Consultation Response from KC Landscape

Application No:	2025/91531
Proposed Development:	Demolition of pair of semi-detached houses and construction of 51 dwellings [amended by applicant to 49 in March 2026]
Location:	Land off Leeds Road, Heckmondwike
Applicant/Agent:	Orion Homes Ltd
Planning Officer	Jillian Rann
Date Responded:	19.08.2025/ updated 13.05.2026
Responding Officer:	Landscape
Responding Ref:	PP33

Figure 2.1
Proposed Site Layout

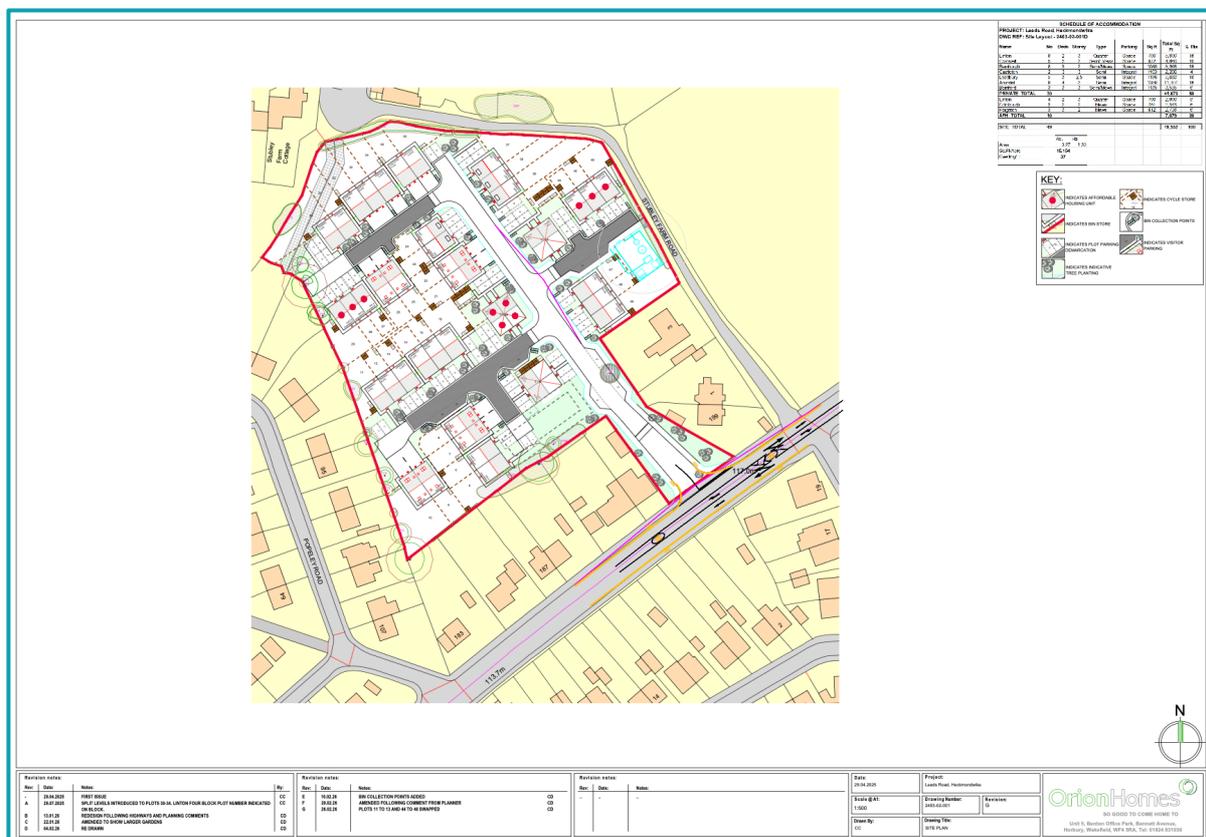
3. The Amenity space plan includes highway entrance verges, parking spaces and gardens which are not public open space (highlighted yellow below). The calculation will need to be revised. As already advised, public open spaces should be "high-quality," and ensure that the green space is substantial enough to accommodate a variety of recreational activities, making it an inviting hub for people to spend time in.

4. Amenity greenspace is required to make the development acceptable and although there is amenity greenspace shown over the attenuation tank, it doesn't look welcoming at present in the current design.

5. Can the trees be planted in the vicinity of the attenuation tank?

13. On site or off site & Existing facilities in the vicinity: There are existing facilities in the vicinity, within the recommended 720m for accessibility of the site, which would require enhancement in lieu of on-site provision, potentially, but not limited to Dale Lane and Firthcliffe Rec and other smaller facilities in the vicinity.

19. The proposed landscape layout drawing is sparse in terms of green structure, landscape proposal does not provide significant improvement to scheme or offer the existing landscape and setting strong enhancement. There is an opportunity to improve existing green structure providing robust mitigation and additional habitat.

21. Will the grassed space provided adjacent to the pumping station be a public open space and if so, how will it be designed and laid out to meet the needs of the widest possible range of users, be easily accessible and enjoyed by all people, regardless of visual, physical and cognitive ability, mobility, background or age, especially if they are just grass over an attenuation tank?

22. The entrance area looks more likely highways verge and entrance planting to meet the needs of BNG rather than public open space.

25. Access to the POS should not be from private drives and is there really no pavement at all next to the green space? The whole scheme seems to have an excessive number of turning heads and private drives. Dead ends and turning heads necessitate increased reversing manoeuvres for all vehicles including resident's cars and vans, delivery vans, lorries and refuse vehicles. Reversing manoeuvres are a risk to H&S for pedestrians and youngsters especially with no pavements or for those accessing green spaces. The numerous dead ends and turning heads should be designed out as far as practicable.

27. The plans submitted /landscaping/ scheme documents do not appear to have taken into account street tree planting in the verges of the estate roads which would be preferred. Trees in rear or private gardens cannot provide the same public amenity and tend to be removed before they reach a size that allows them to contribute to the setting of the development.
